From: Michael Eastham
Sent: 14 June 2018 12:17
To: Planning.Responses
Subject: FW: Planning Consultation on: A/40/18/OUT

Please upload the emails below onto Ocella as a response from the applicant to ADC Greenspace's consultation representation to A/40/18/OUT – Land North of Water Lane, Angmering.

Comments from Greenspace

**Drawing title:** Tree Retention Plan

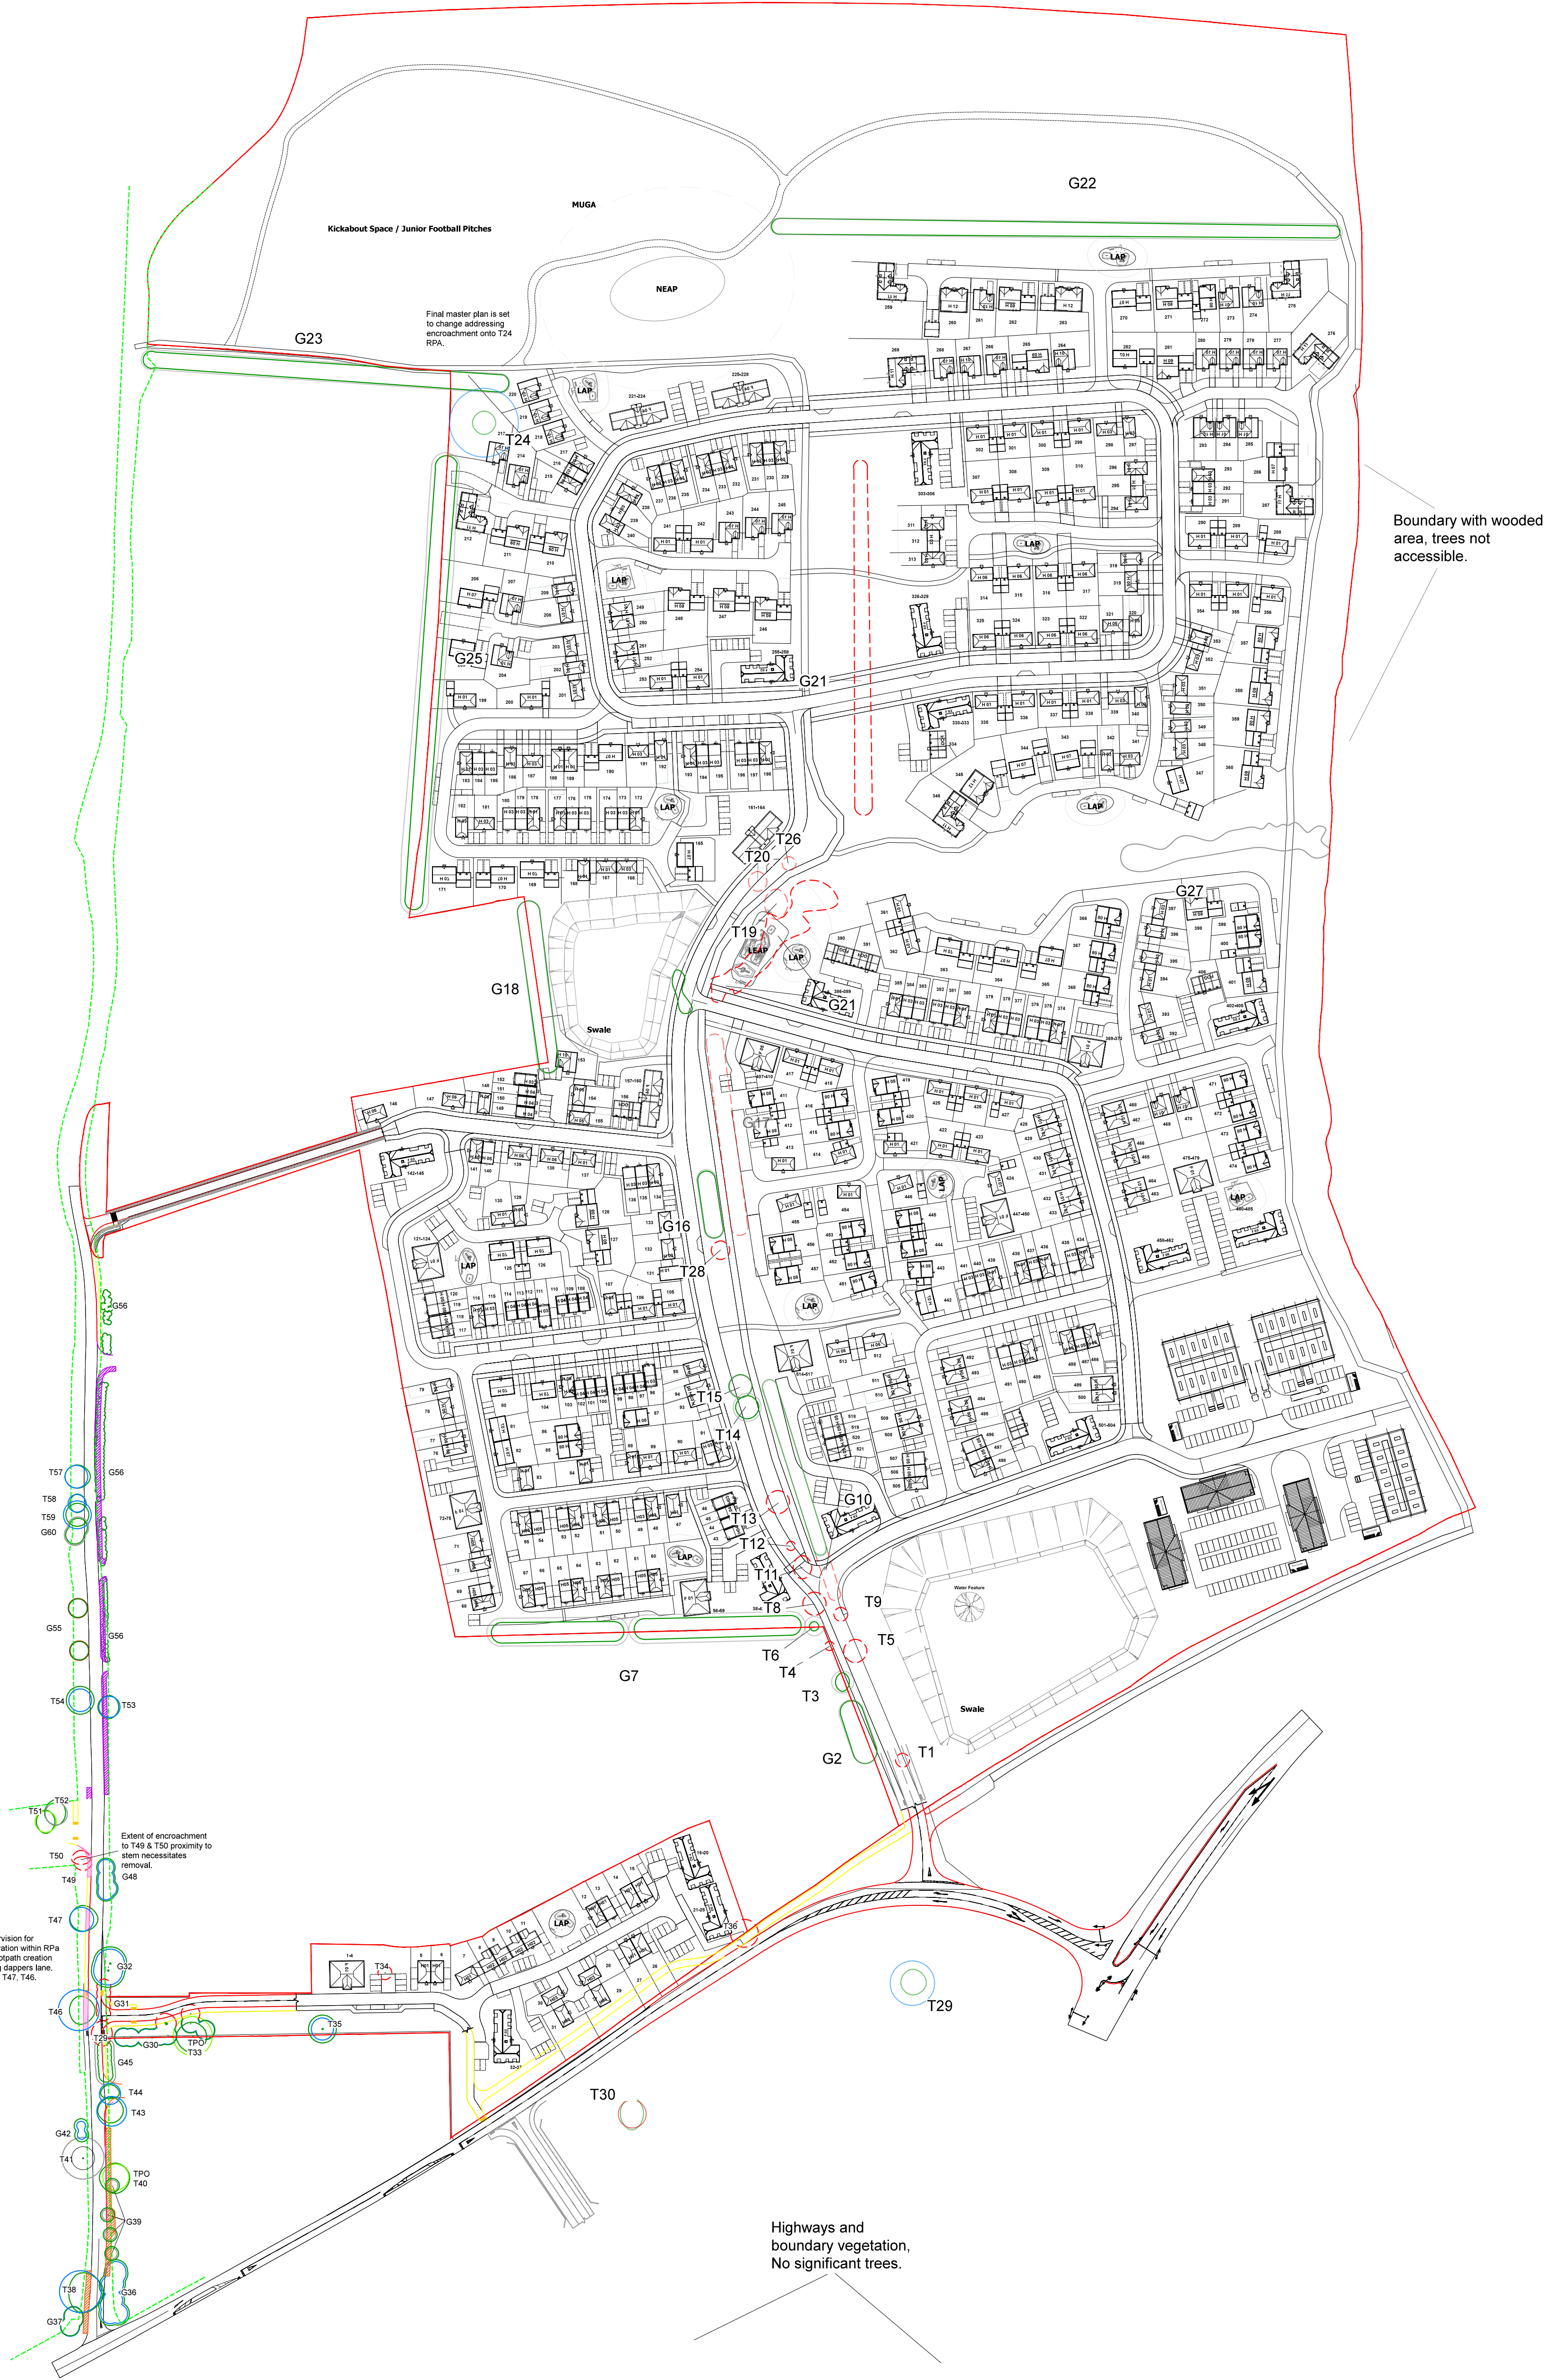
Landscape – Existing trees or vegetation that fall within the proposed or periphery of the development, may provide significant aesthetic impact to the location. Any trees in particular along the boundaries, which adjoin neighbouring properties could provide potential valuable screening and should be protected and retained. Any considered tree works within the site should be agreed with Arun District Councils Tree Officer. Further information concerning the existing hedges across the site and proposed TPO for worthy trees will need to be provided. A tree condition survey of the application site to be provided to highlight the importance of retaining particular trees along with the condition of existing hedgerows locally and their contribution to the landscape should be included. Root protection Areas (RPA) from the tree cover clearly seen to the periphery and in several locations of the site should extend into the development site. Before construction, a tree protection scheme must be in place for these adjacent trees whose root protection areas fall within the construction zone from neighbouring land. This would be required for both construction and

heavy vehicle movements for deliveries. This should be in accordance with BS 5837:2012 'Trees in relation to construction'
